M3 Junction 9 Improvement

Scheme Number: TR010055

7.12.1 Statement of Common Ground with Winchester City Council (Rev 1)

7.12.1 STATEMENT OF COMMON GROUND WITH WINCHESTER CITY COUNCIL

**PROJECT STAGE**  
 PCF STAGE 3

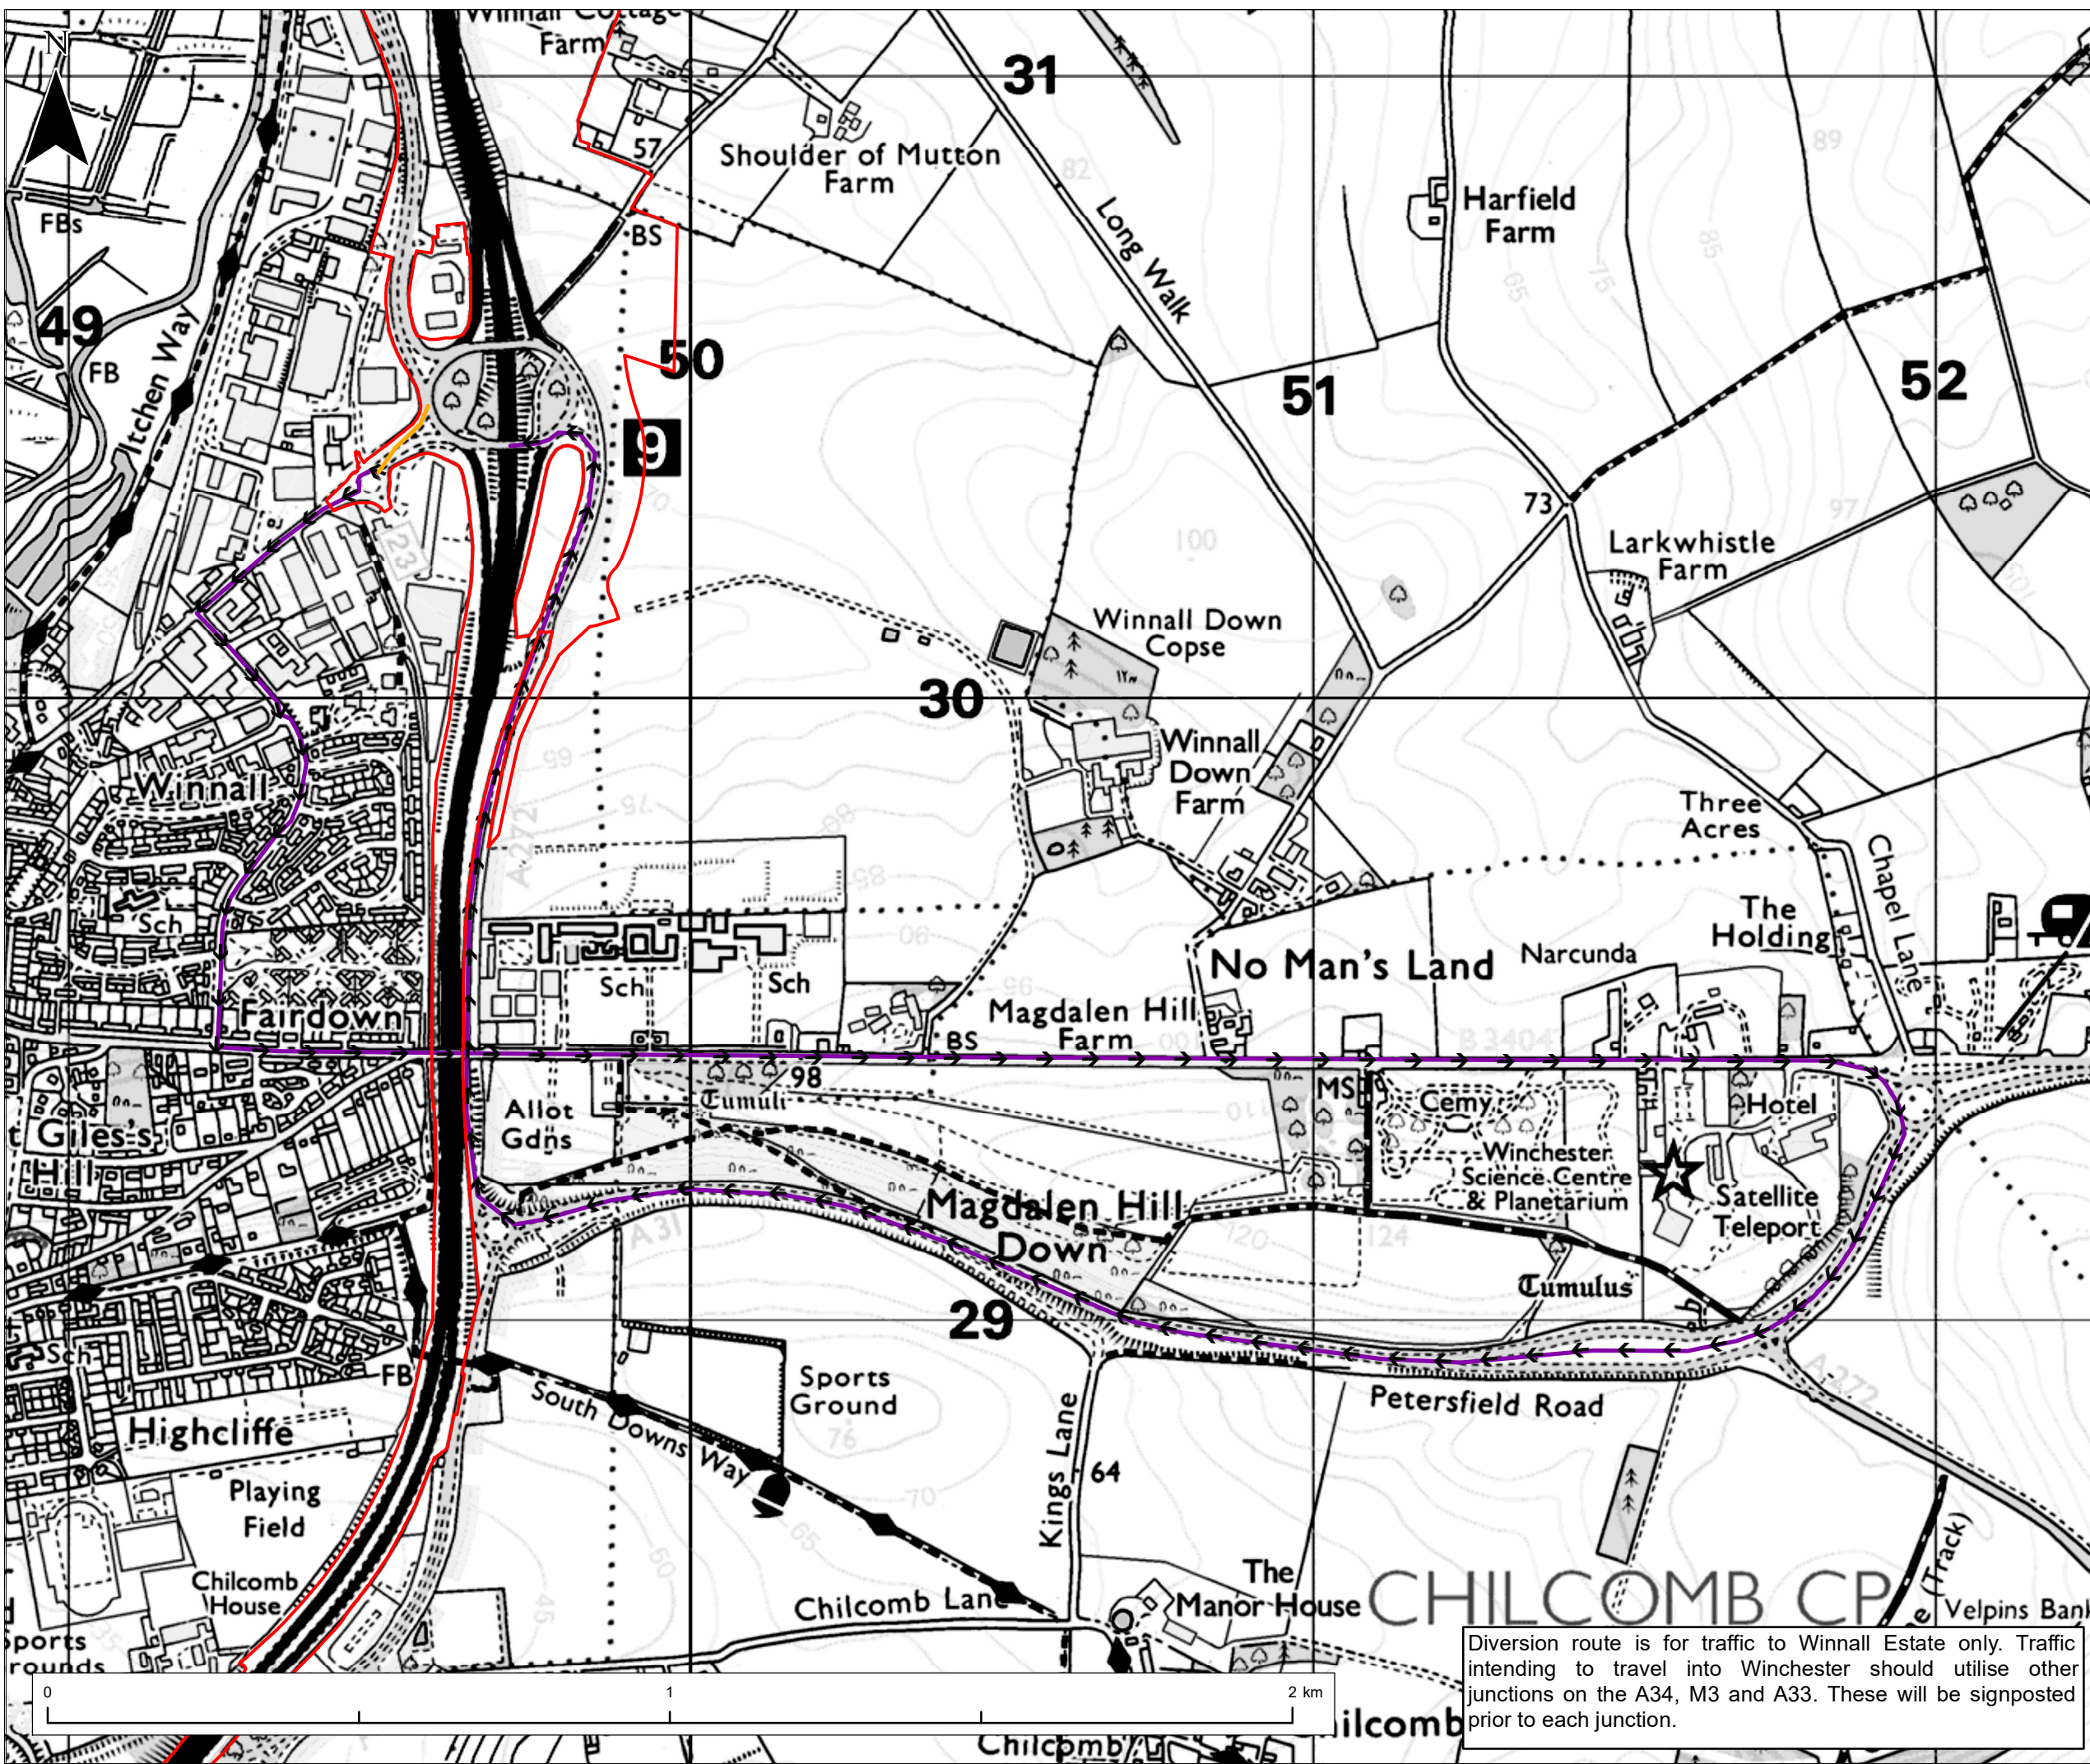
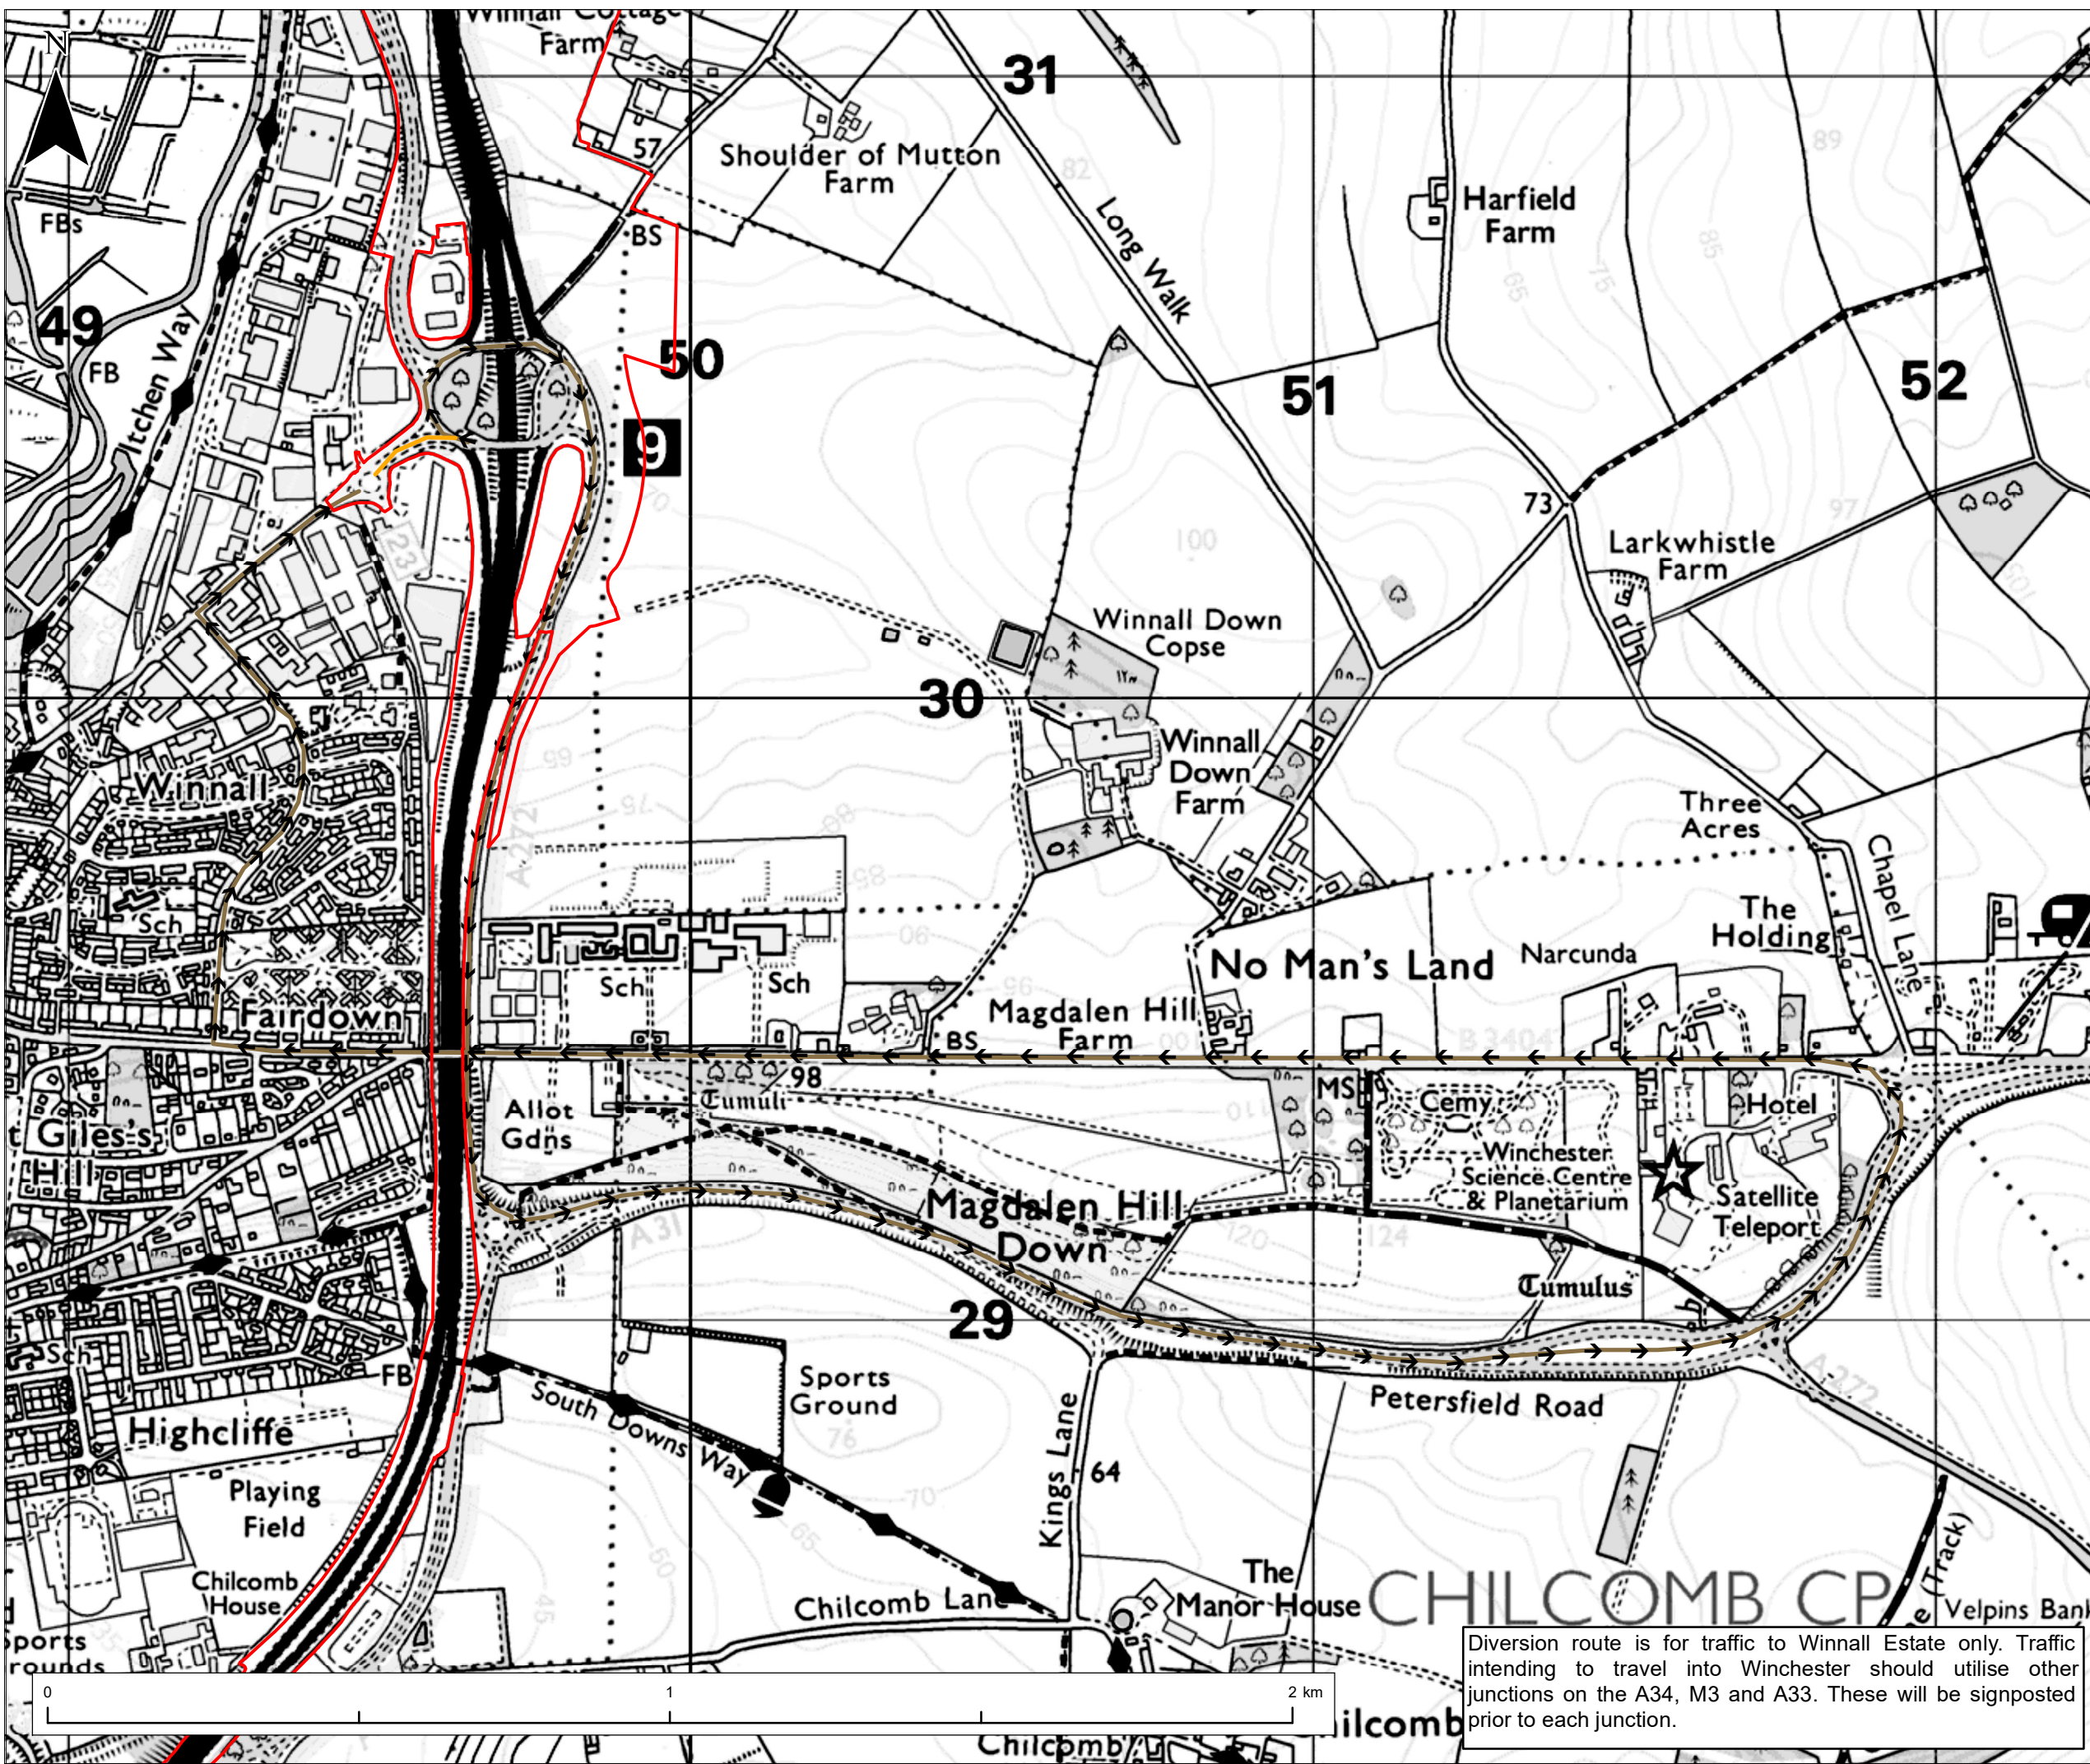
3.6	Mitigation Section 5.8 of Chapter 5 (Air Quality) of the ES (6.1, Rev 1) outlines the essential mitigation during construction.	Chapter 5 (Air Quality) of the ES (6.1, Rev 1)	Although this has been covered in Environmental Statement - the air quality and noise impacts assume indicative diversion routes are used that in reality do not seem to realistic to likely resultant patterns at such times. At ISH2 it was confirmed that discussions will be held between the Highway Authority and Applicant concerning advanced positioning of signs and general methods to ensure compliance with	National Highways is reviewing Winchester City Council's recent comment on this matter.	Under Discussion	18 August 2023
